SF2015/006050
CR2015/000328
MJ

**NEW ENGLAND HIGHWAY (A15): MOUNT OWEN CONTINUED OPERATIONS PROJECT,
RAVENSWORTH – EXHIBITION OF ENVIRONMENTAL IMPACT STATEMENT– SSD 5850**

I refer to your email dated 21 January 2015 regarding the Environmental Impact Statement (EIS) for the proposed Mount Owen Continued Operation Project, forwarded to Roads and Maritime Services for comment.

FIGURE 2.15  
Hebden Road Upgrade Works  
Conceptual Design

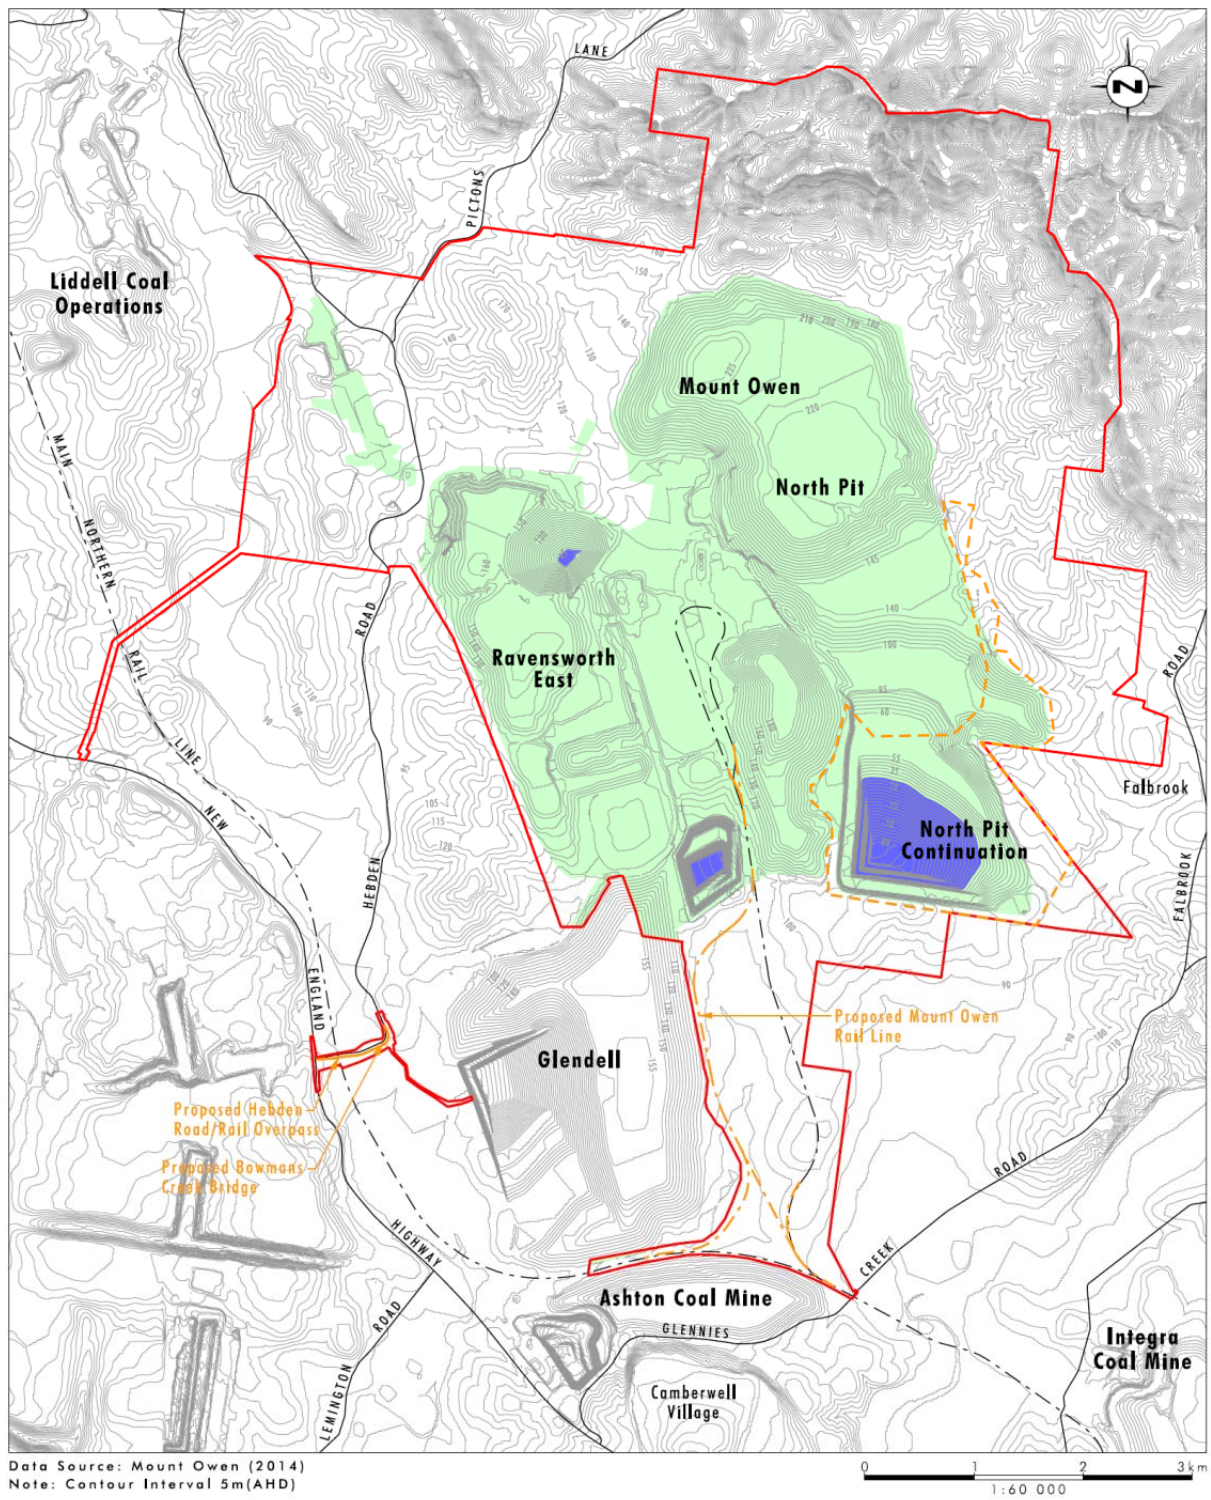
Roads and Maritime requires the applicant to provide a concept design of the road works proposed in Hebden Road, including the vertical alignment (long section) from the existing New England Highway intersection to the proposed new bridge over Bowmans Creek, to Roads and Maritime for review.
